CITY OF ALBUQUERQUE

March 23, 2012

**Re: 8324 Washington Street NE,
Request for Permanent C.O. - Disapproved
Engineer's Stamp dated: 01-17-12, (C17/D012)
Certification dated: 03-14-12**

8324 WASHINGTON STREET N.W.
DETAILED GRADING AND DRAINAGE PLAN

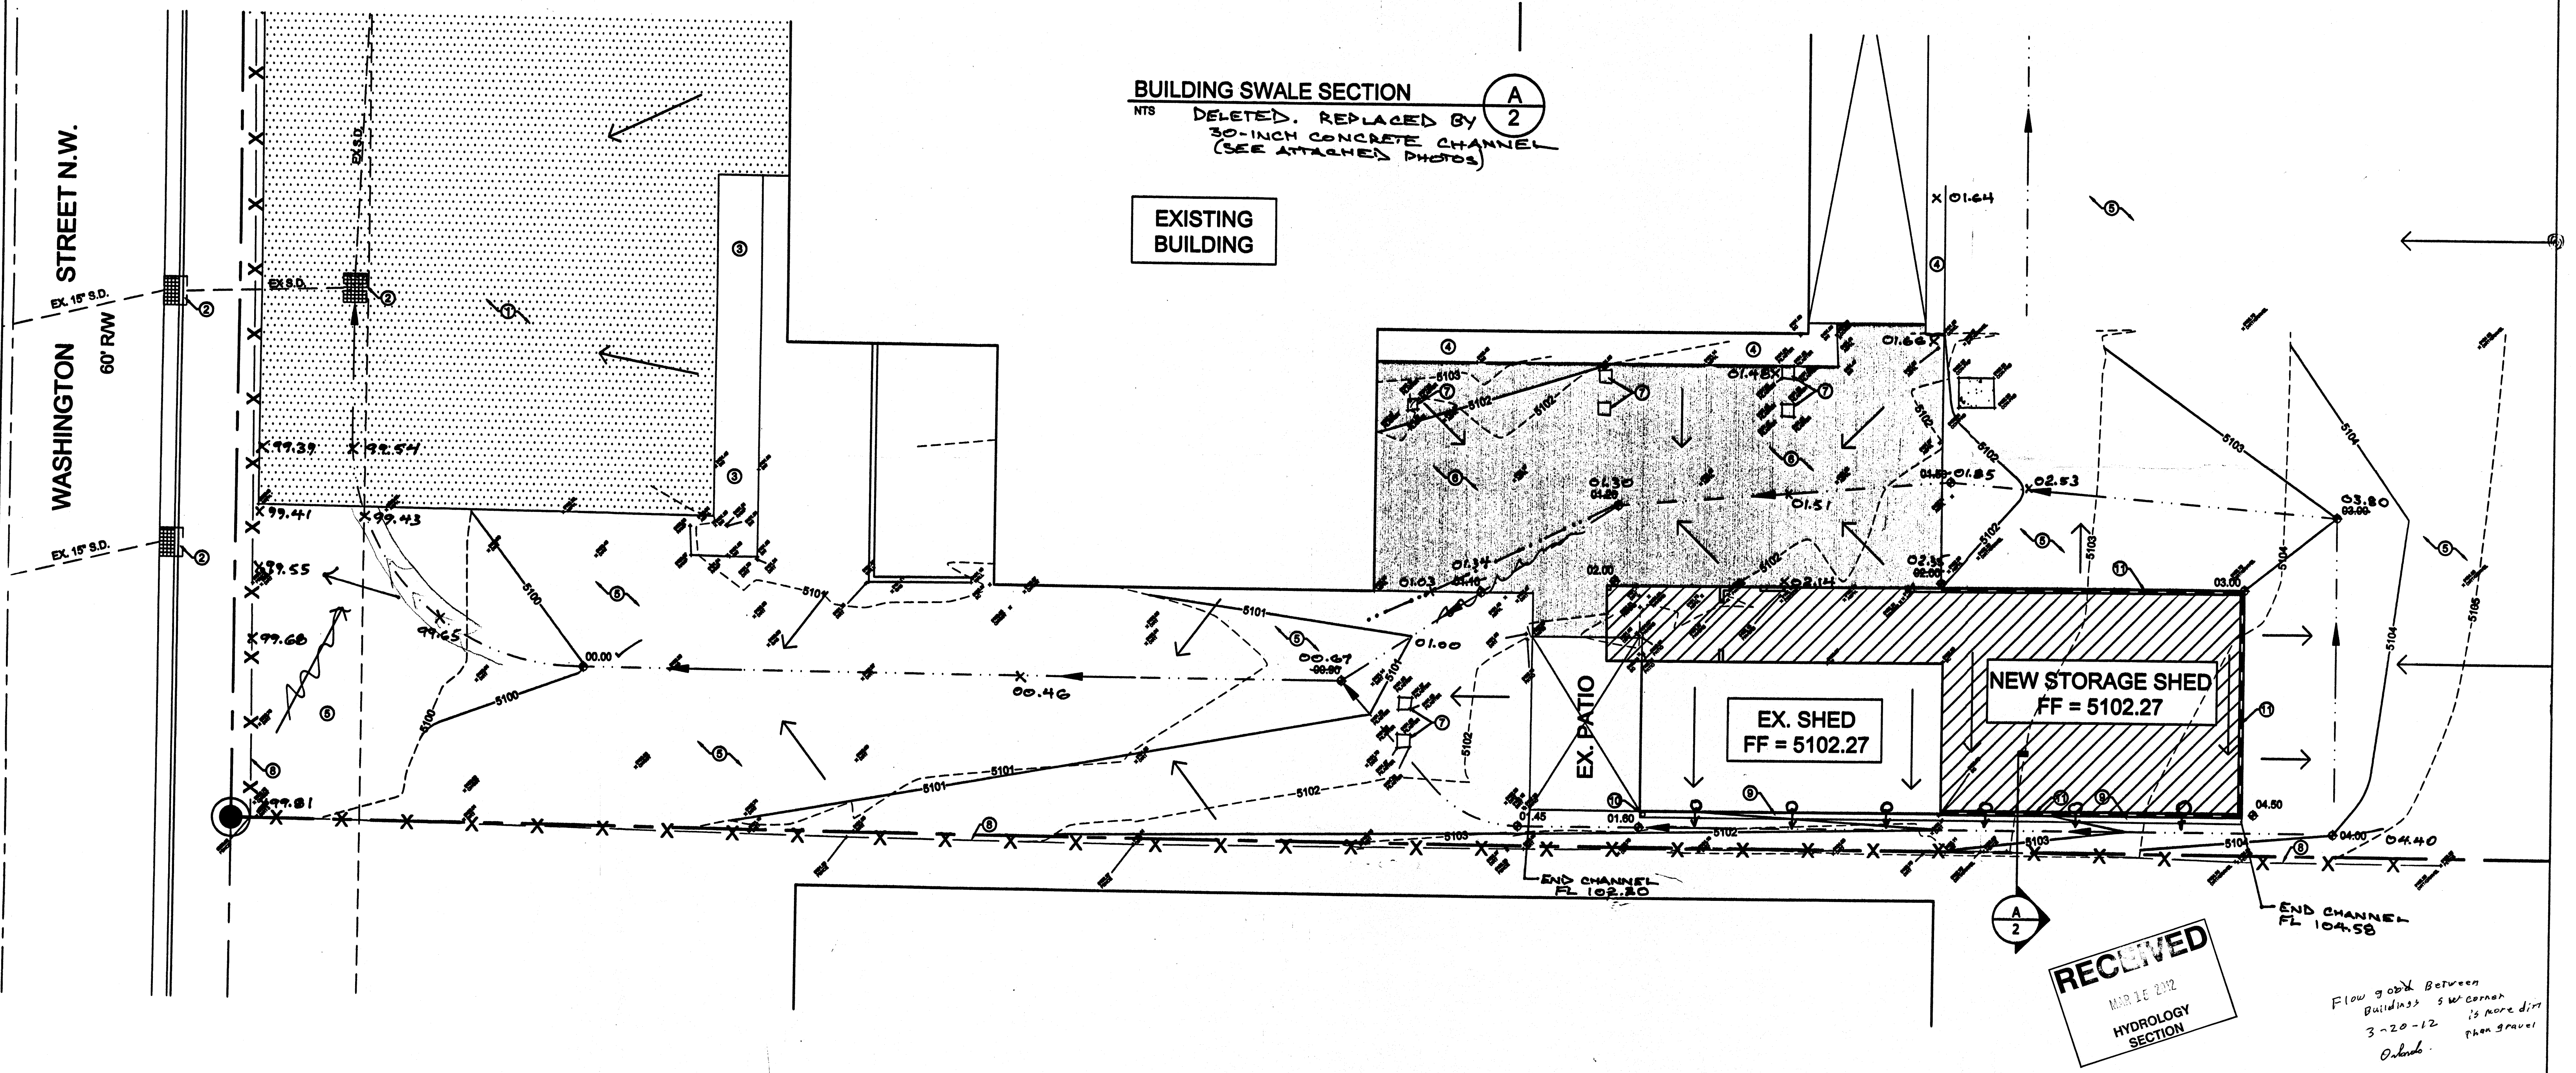
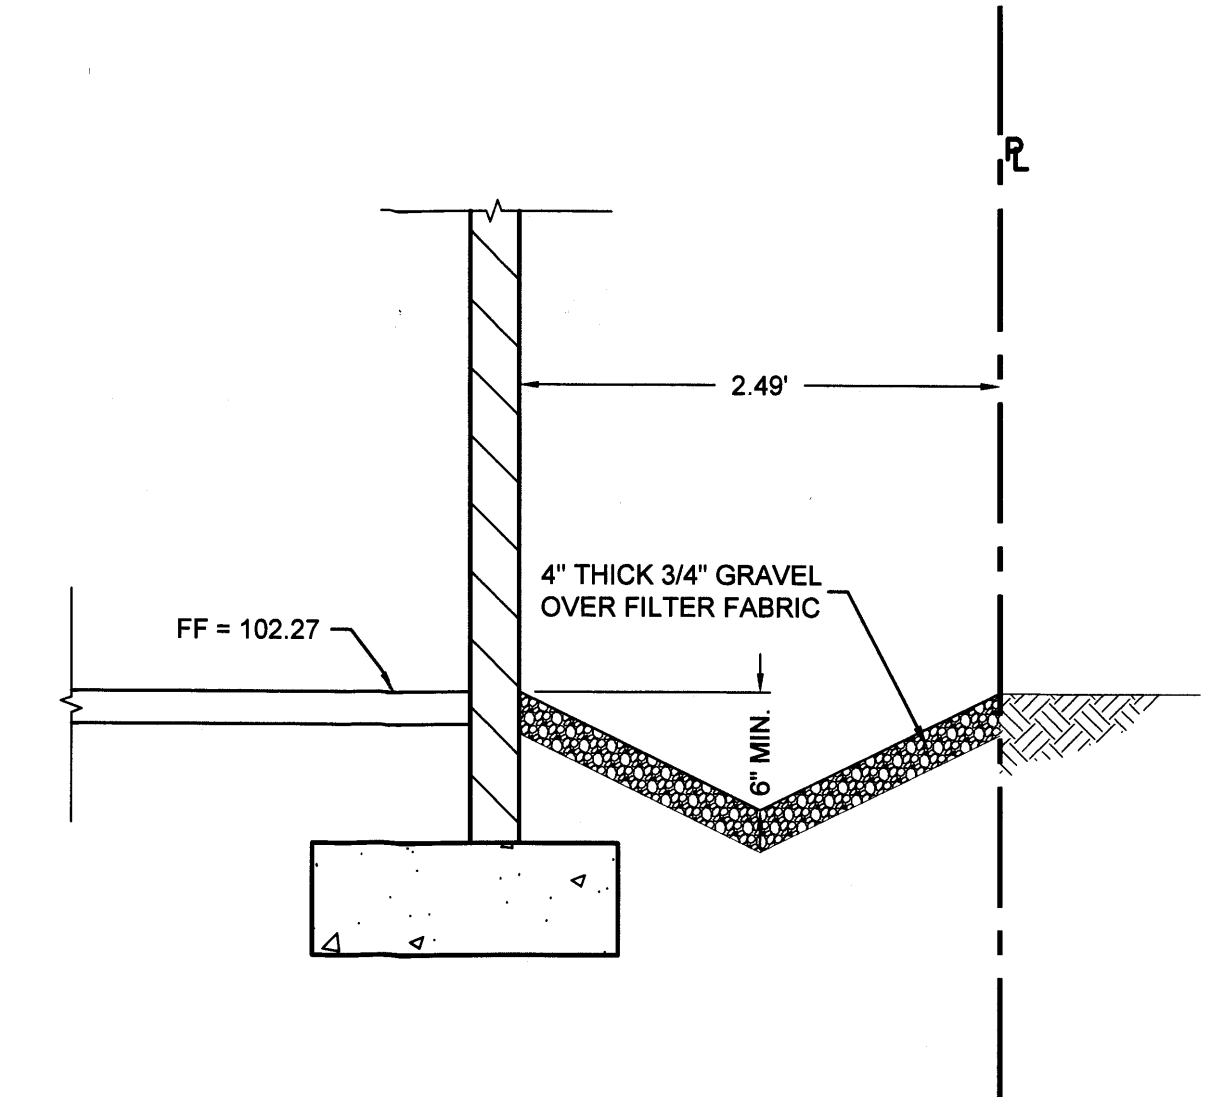
The onsite swale will need to discharge into the existing onsite inlet. Additional grading is required to achieve positive drainage to this inlet. Include the grate elevation and edge of asphalt, (west of the grate), at the fence line with the next certification.
